**3 MURRAY ROSE AVENUE
SYDNEY OLYMPIC PARK**

ACCESS REVIEW

Morris-Goding Accessibility Consulting

27th July 2012

PROJECT TITLE
3 MURRAY ROSE AVENUE
SYDNEY OLYMPIC PARK
DRAWING TITLE
Basement 03 Plan

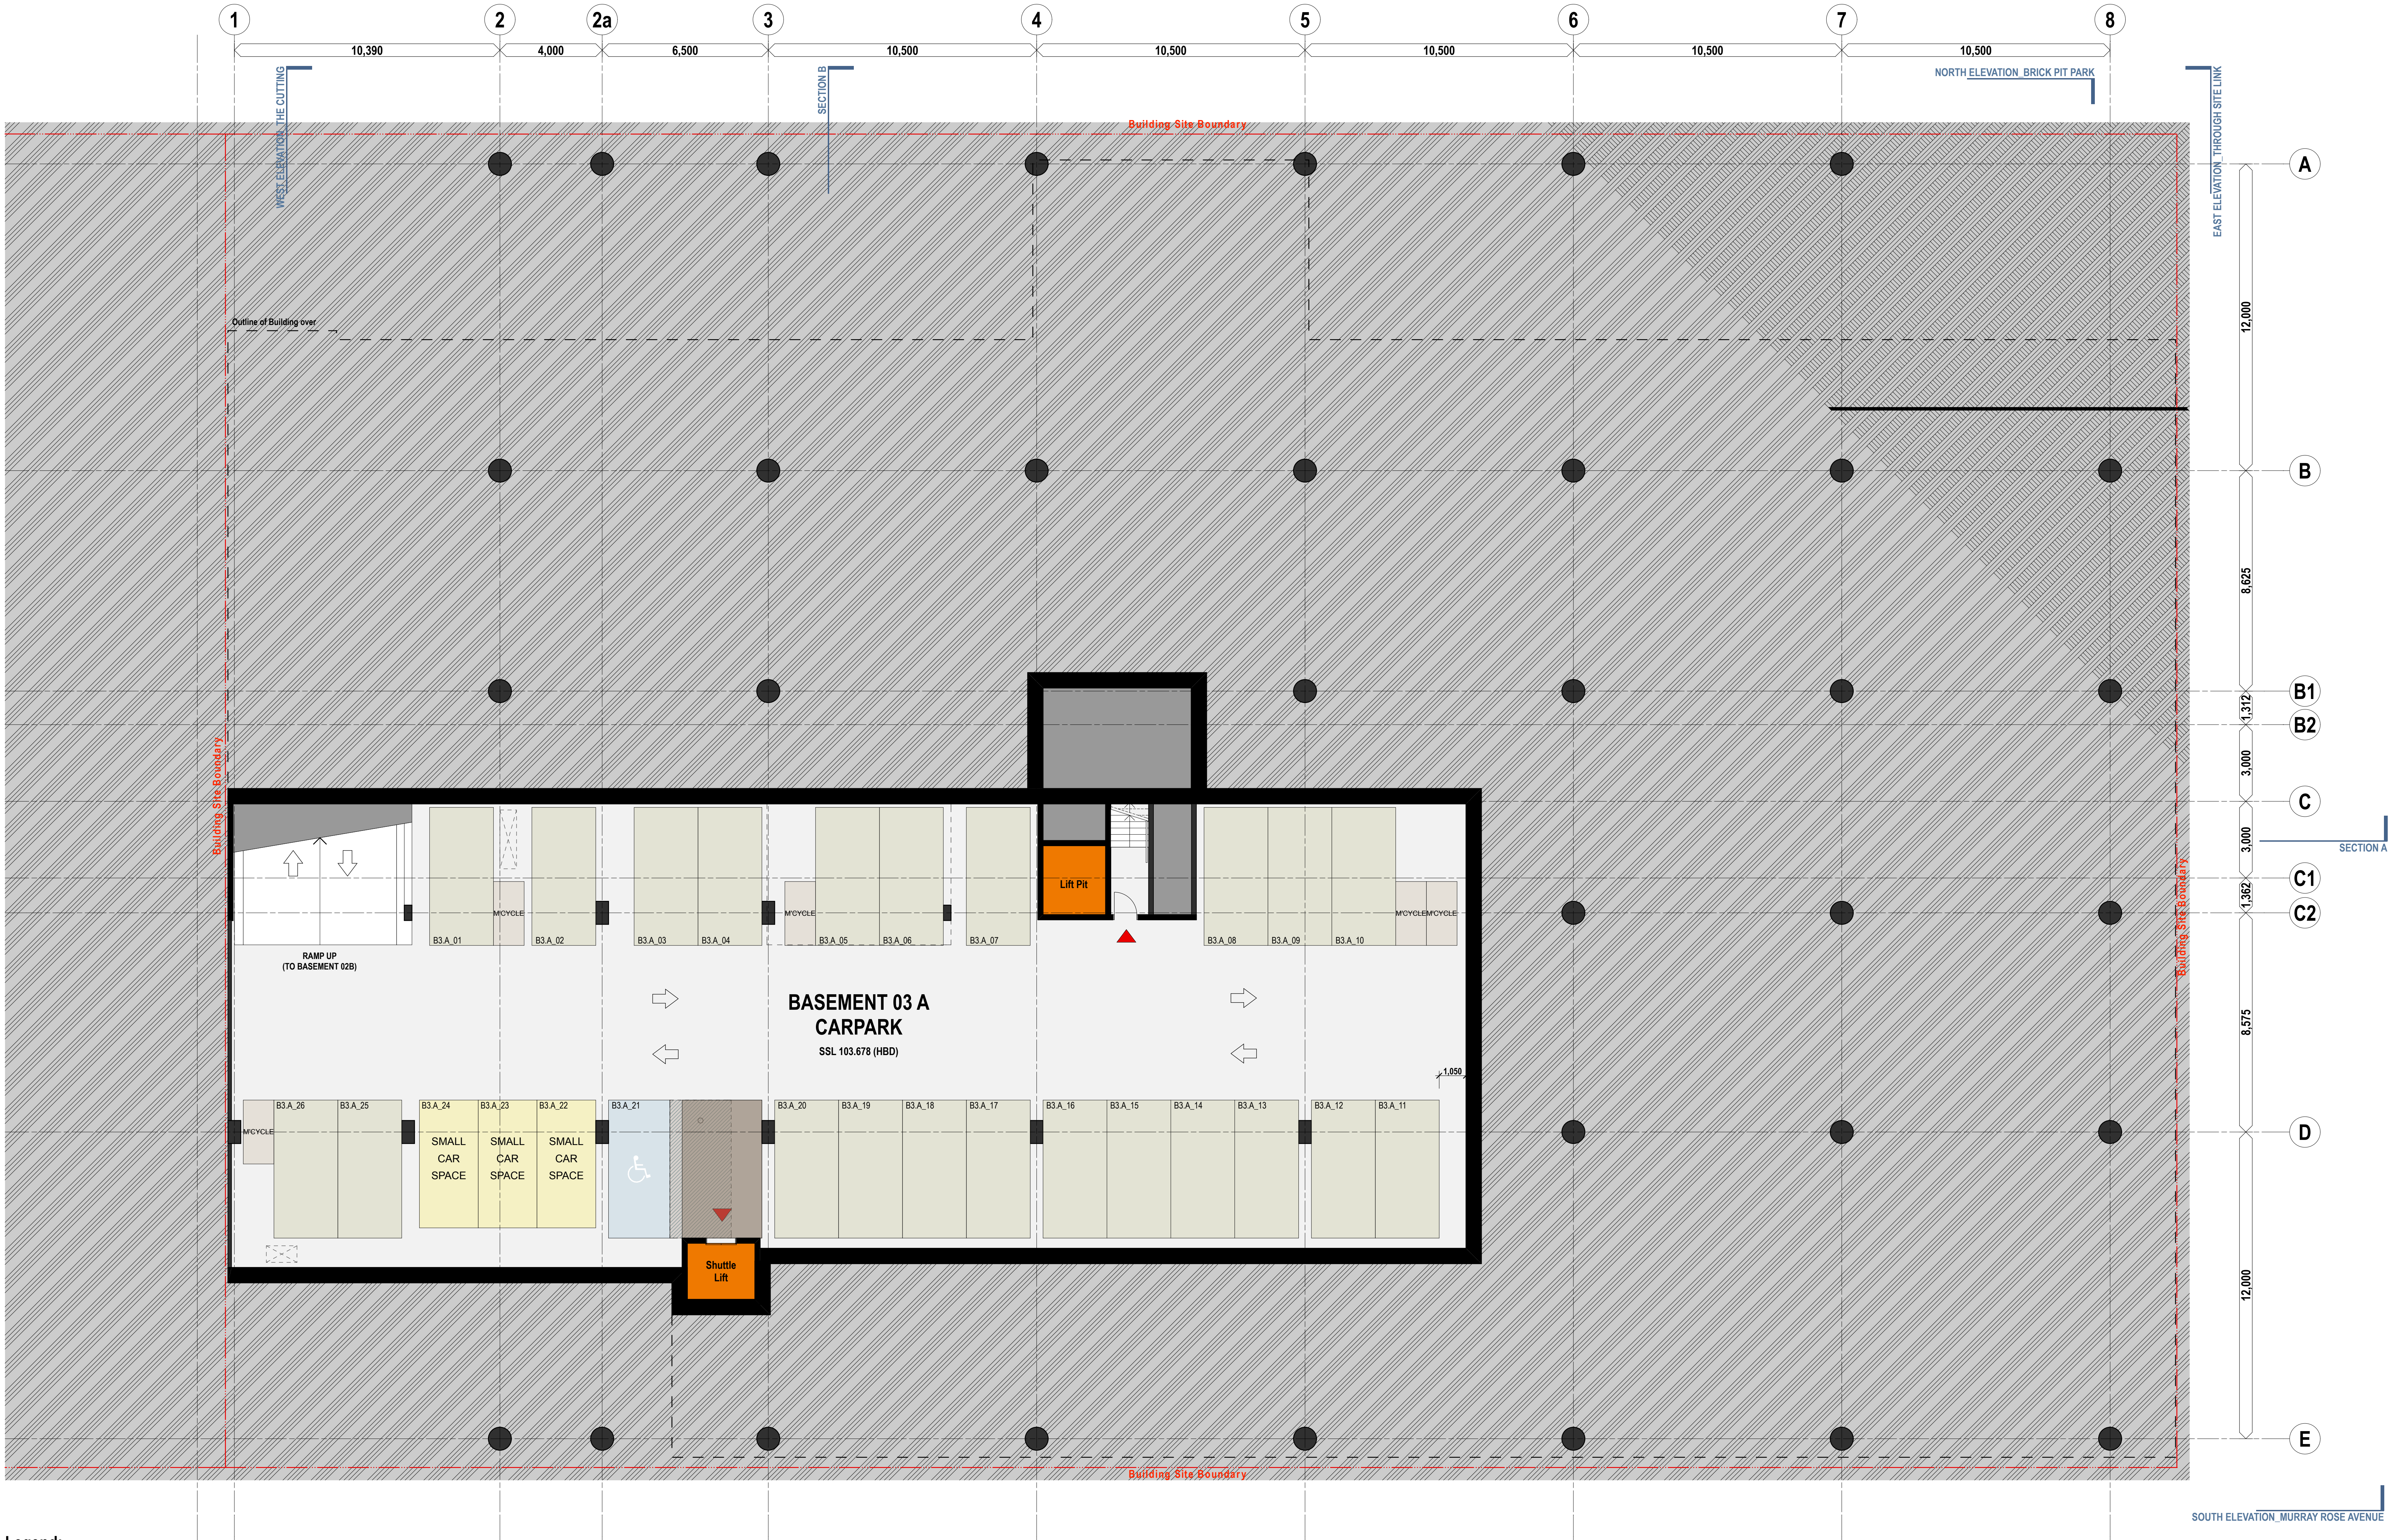
There are 4 basement levels of car parking available within the building with a total of approximately 249 car spaces. A total of 8 accessible parking bays have been provided that are spread across all 3 levels. The total of 8 accessible parking bays satisfies compliance with the DDA Premises Standards D3.5 and BCA table D3.5, as well as the 3% bays required by Sydney Olympic Park Authority DCP 2011 Section 7.3.

The accessible car bays have dimensions of 5400mm x 2400mm compliant with AS2890.6. At each of these bays, a shared area with dimensions of 5400mm x 2400mm is provided beside the bay and a shared area with dimensions 2400mm x 2400mm is provided at the end of the bay, complying with AS2890.6. All bays are located in close proximity to the lifts compliant with Sydney Olympic Park Authority DCP 2011 Section 7.3.

- (i) Ensure accessible car bays have a vertical clearance of 2.5 metres, compliant with AS2890.6.
